Our Ref: BE/83/19/HH
Your Ref:

Town & Country Planning Act 1990 (as amended)
Town & Country Planning (Development Management Procedure) (England) Order 2015
Application for Planning Permission for Works or Extension to a Dwelling

Development Single storey rear extension

Location 13 Central Avenue Bersted

Block Plan

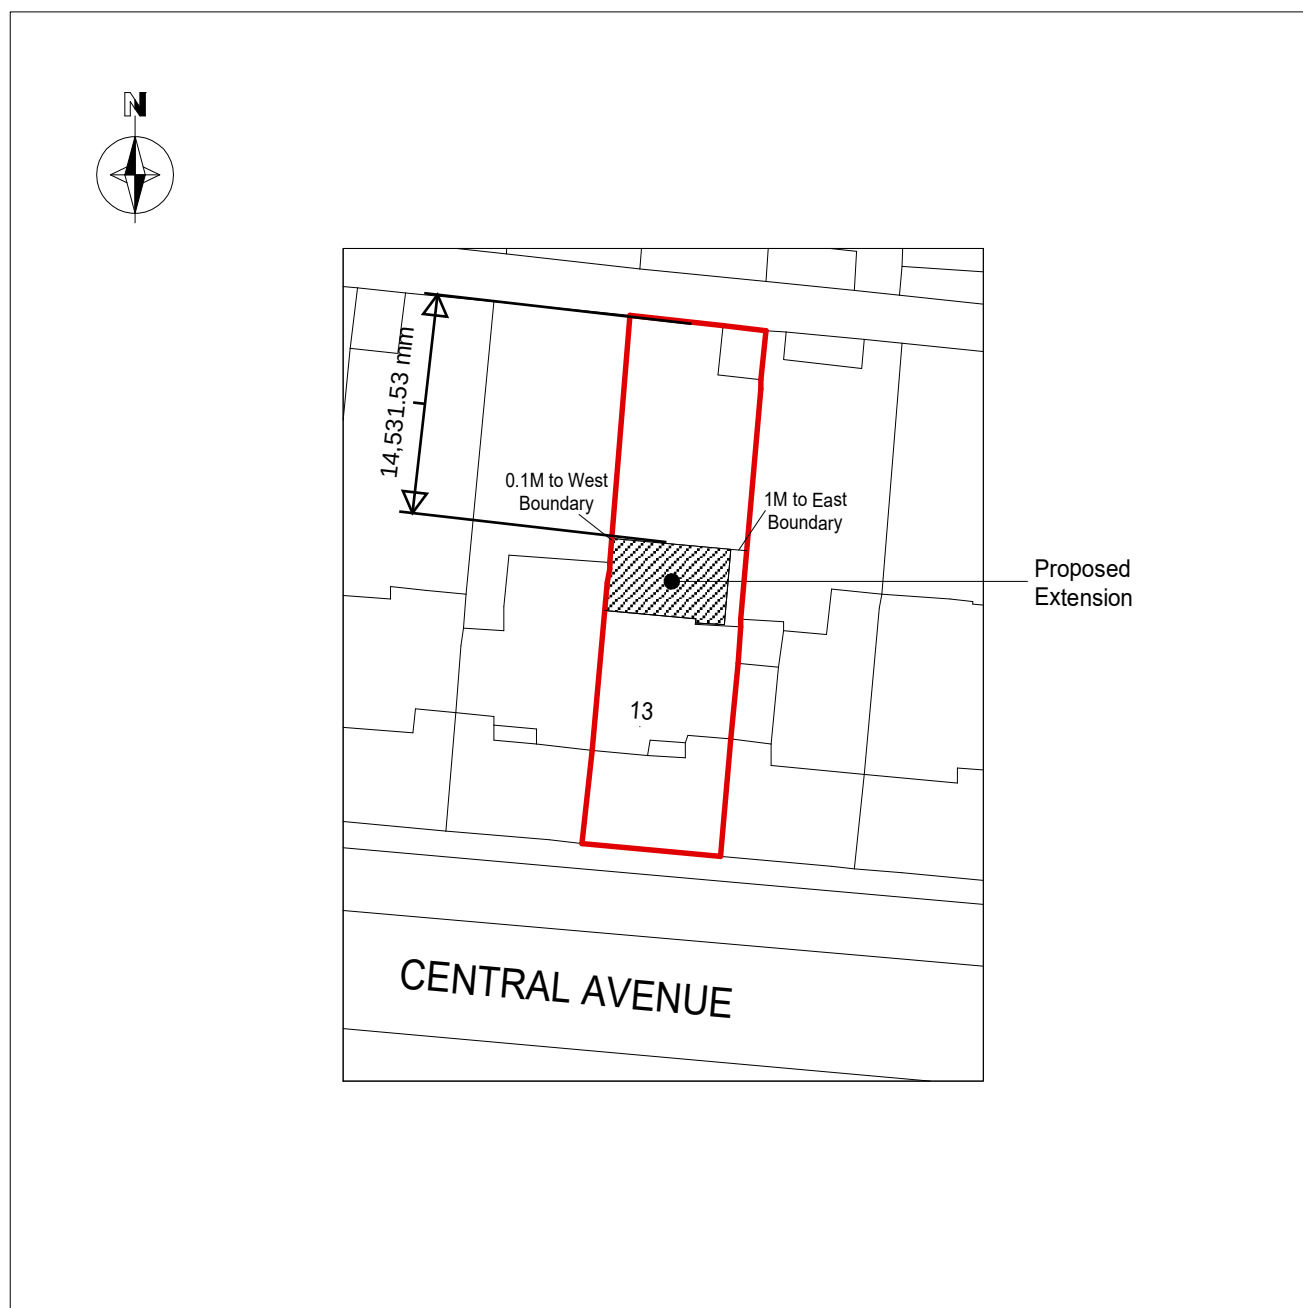
Please submit a block plan which includes dimensions from the proposed extension to all site boundaries.
